PROJECT: Kellyville Station Precinct SSD 10343
RE: SDRP SESSION 40 – 25.09.19 (first review)

RE: PROJECT: Kellyville Station Precinct SSD 10343
SDRP SESSION 51 – 08.04.20 (Second Review)

Figure 23: The built form for Lot A must maximise solar access into the Station Plaza during the winter solstice

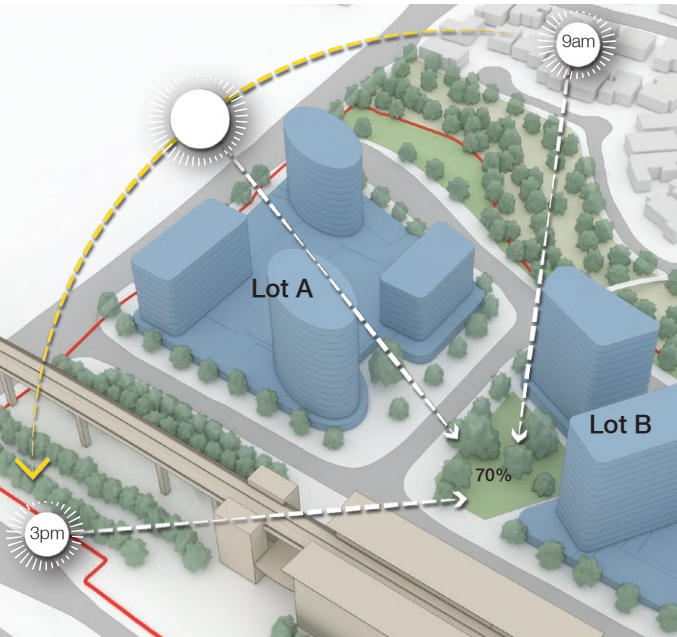
- Location of the Block B through-site link is not yet resolved, as it does not connect through to a logical destination or significantly break down the bulk of the block. Alternative options for its location, and/or the addition of a second link in this Block are required.
- Provide solar access diagrams for the new town square that demonstrate overshadowing from towers to the North is acceptable.
- Design guidelines to mandate solar access. Recommended that 70% of open space should receive minimum 4 hours of sunlight at Winter solstice.
- Provide solar access diagrams for all public open spaces.
- Confirmation that the proposed public domain and open space provisions are consistent with State Government targets and priorities.

Figure 29: Darani Avenue Cross section

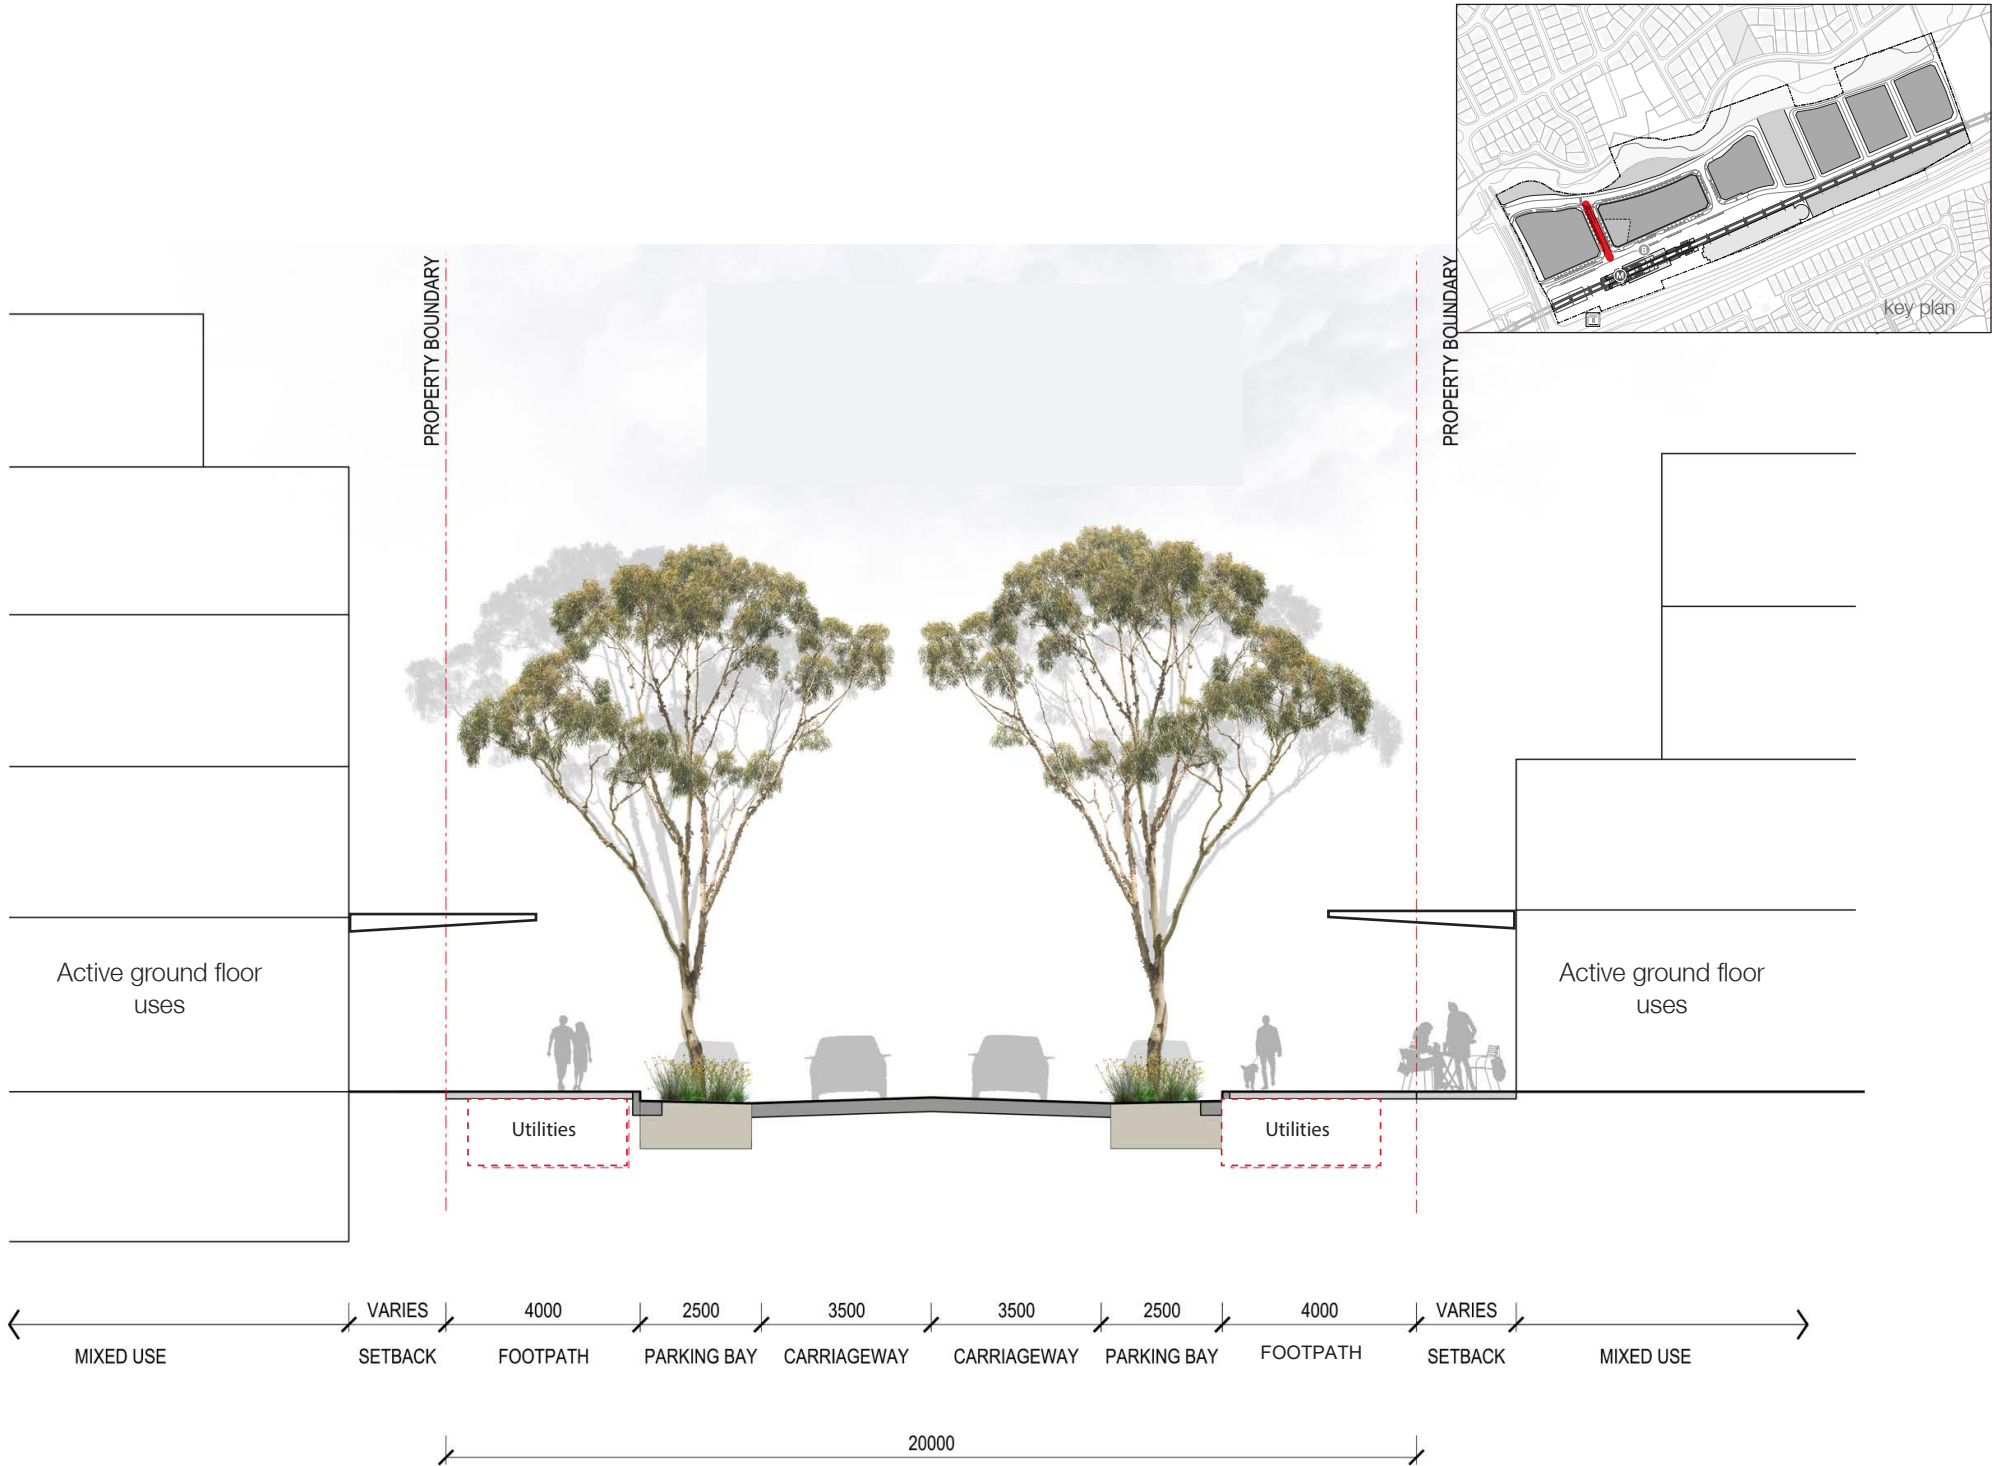
- Provide street section at the carpark entries along the eastern edge of the site that include the creek corridor, demonstrating that this interface will not interfere with pedestrian movement.

- Ensure all detailed street sections are incorporated into the Design Guidelines to ensure delivery of the proposed road types. Street sections to be developed with the Landscape Architect to demonstrate optimum utilisation of the streets. These need to be consistent with those proposed for Bella Vista.

Figure 49: Street setback plan 1:7,500 @ A3

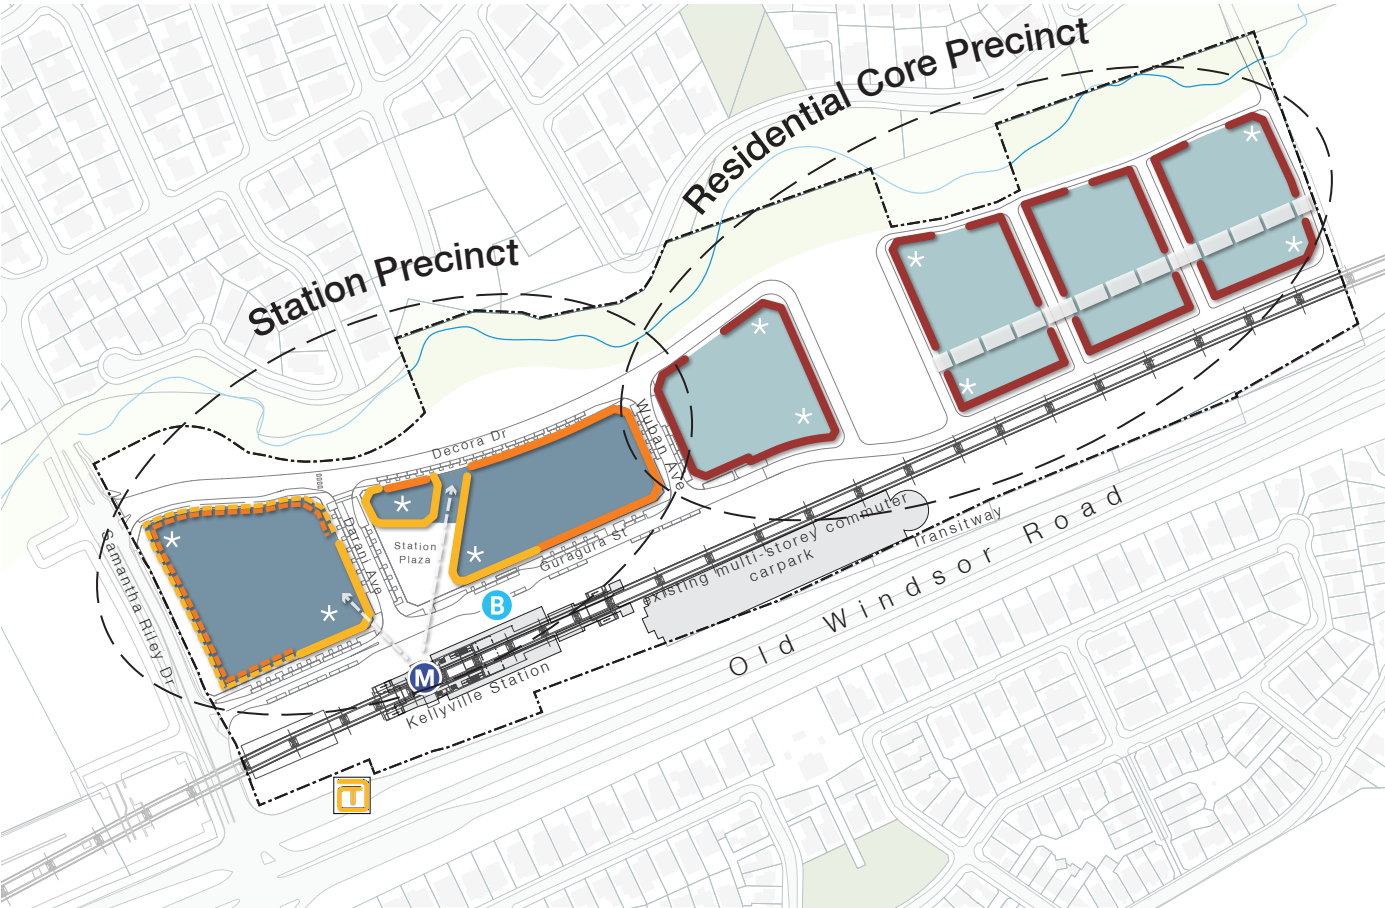
- Demonstrate how reduced street setbacks accommodate street tree provisions, provide opportunity for increased courtyard canopy planting and more generous private open spaces independently from any increase in GFA.
